From: Laura Gibbons
Sent: 15 October 2018 16:11
To: Planning.Responses
Subject: RE: Planning Consultation on: FG/159/18/PL

Engineers Comments Regarding Flood Risk and Surface Water Drainage

APPLICATION **FG/159/18/PL**

Description of Works: Two-storey extension to the existing Cafe in order to provide increased internal seating, multi-purpose space, with improved service & food preparation area, disabled access & bike storage.

02 Proposed Site Plan
1002 Scale: 1:200

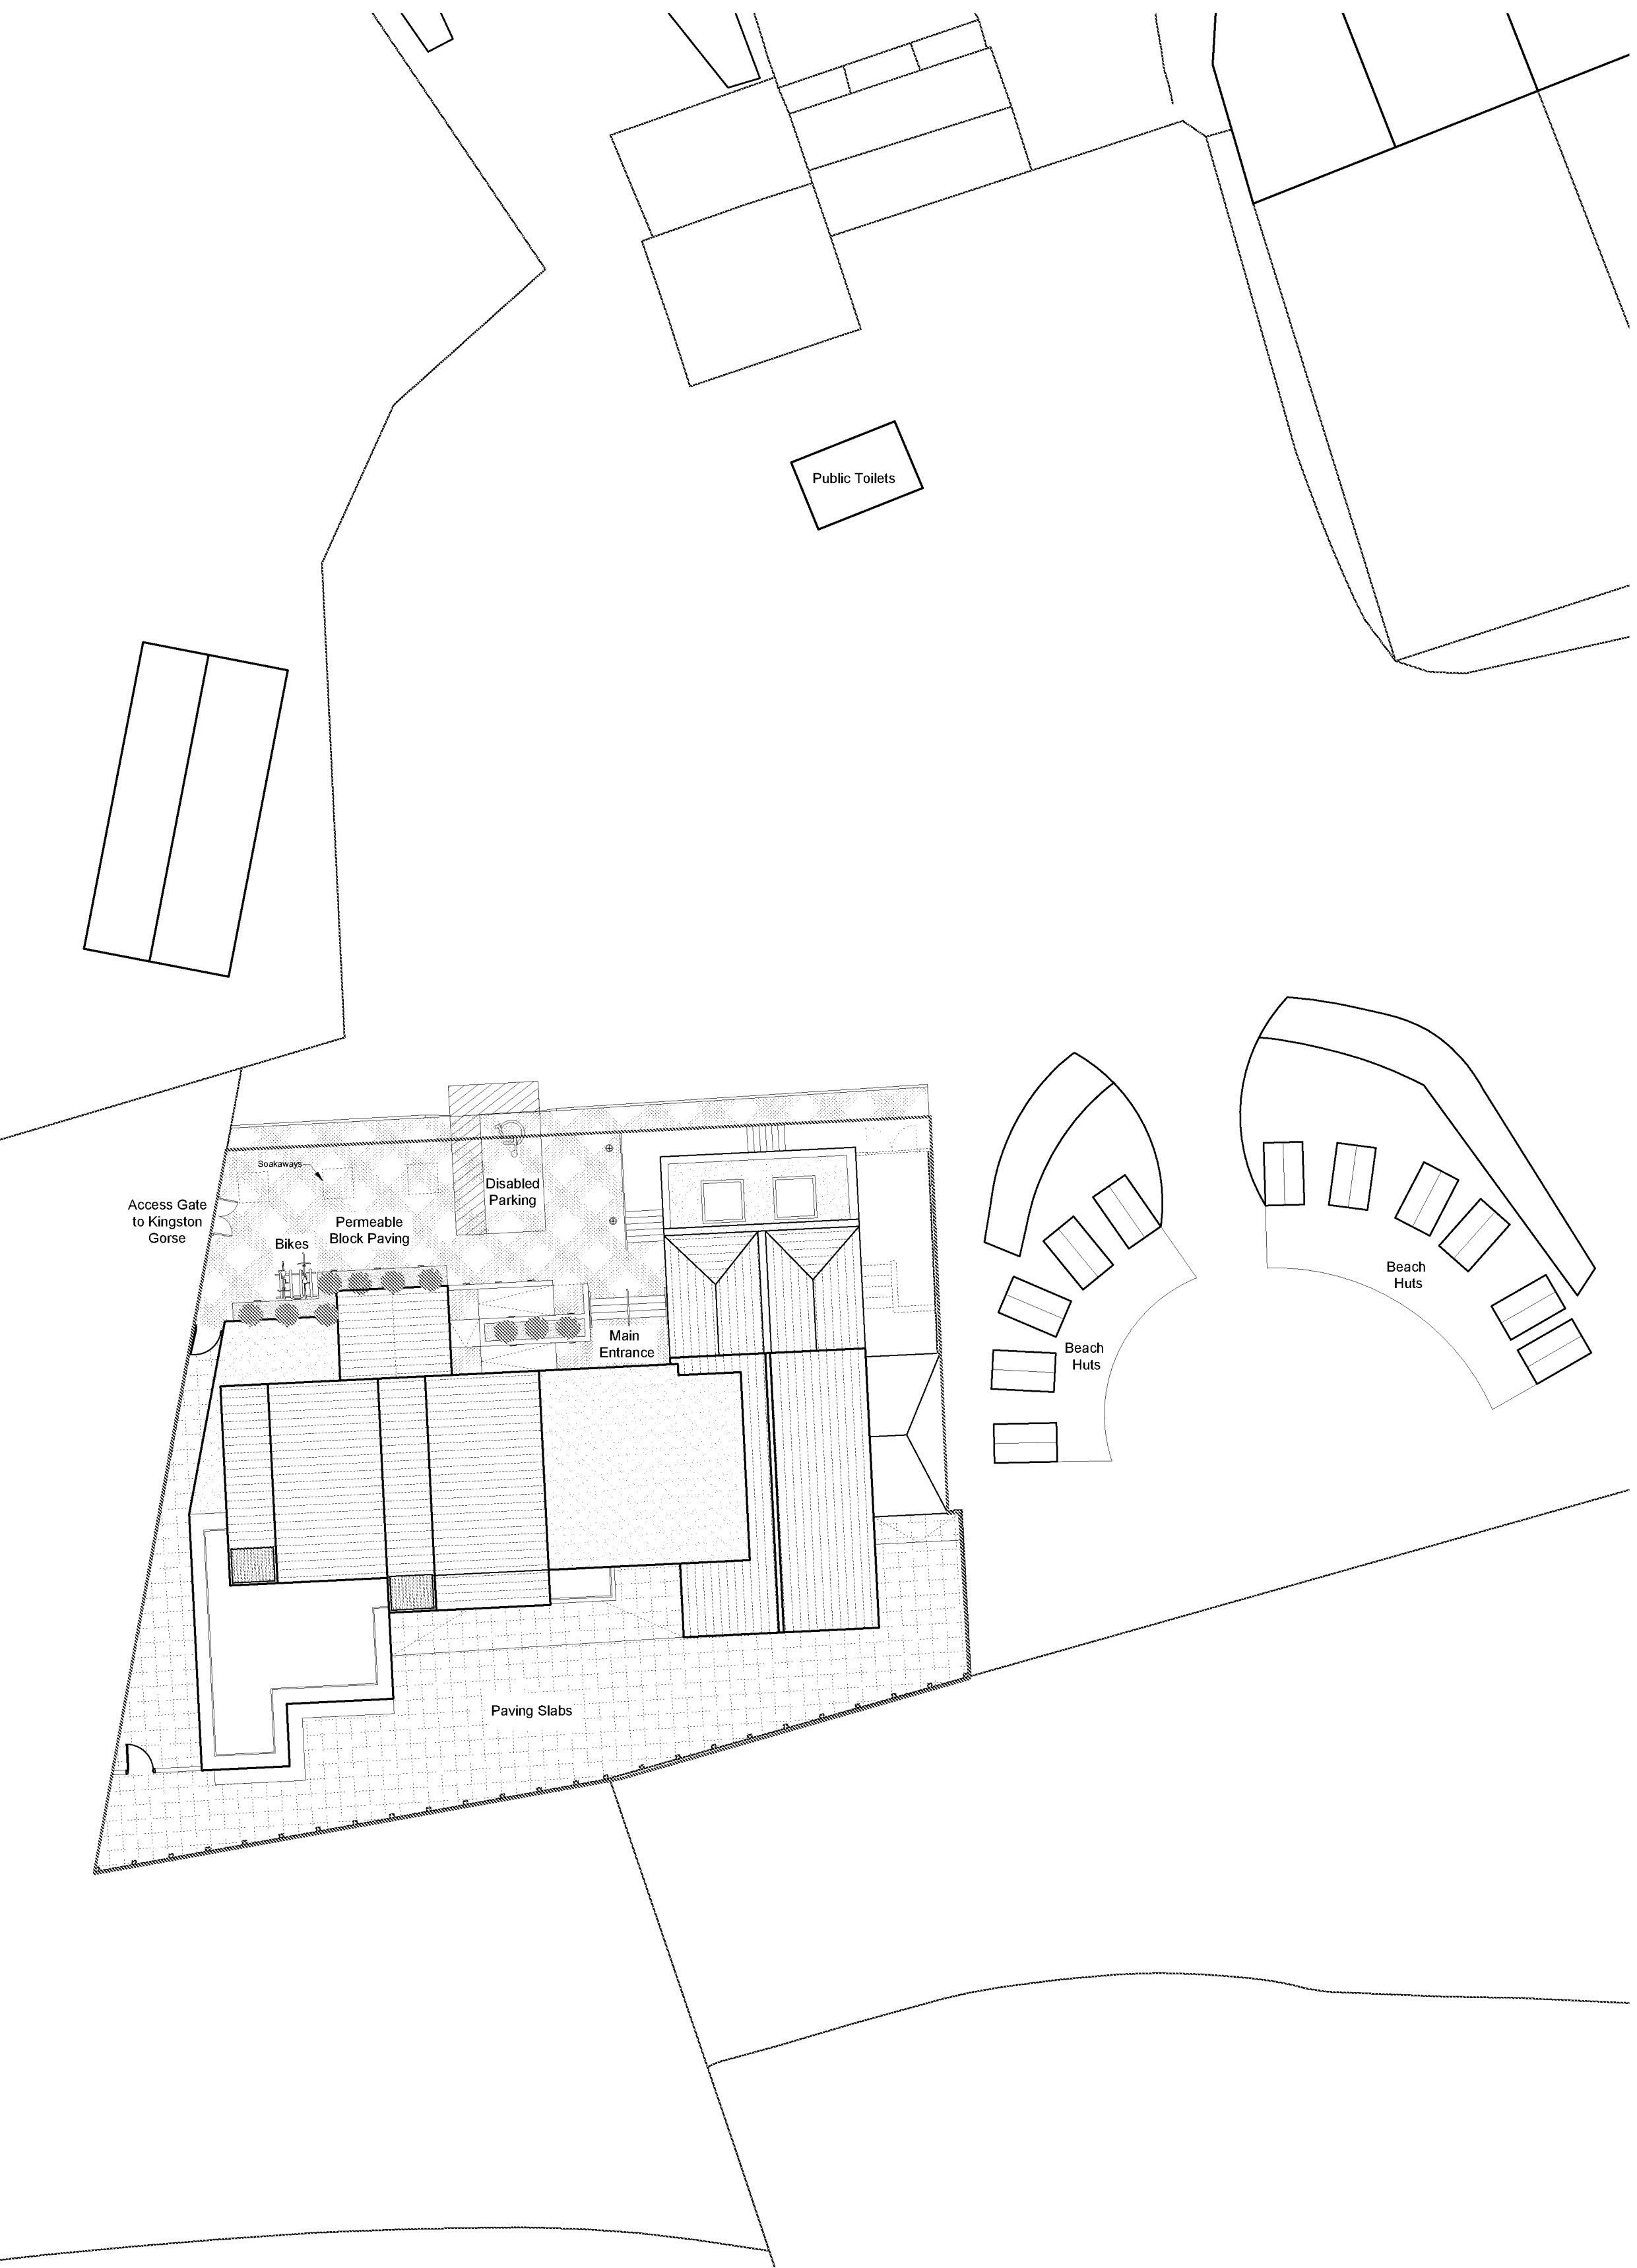
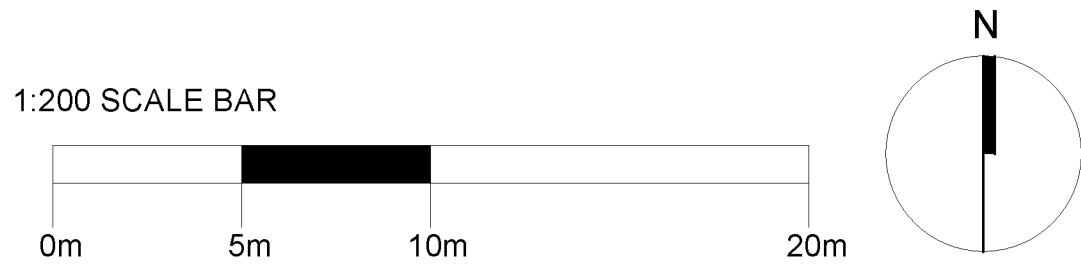
The application is within flood zone 3 and therefore the Environment Agency should be consulted. Furthermore the proposed building will be located between the existing and old Ferring Rife Outfall.

It is proposed that the surface water is discharged to soakaway. This is acceptable in principle. The soakaway should be designed and built to meet building regulation requirements.
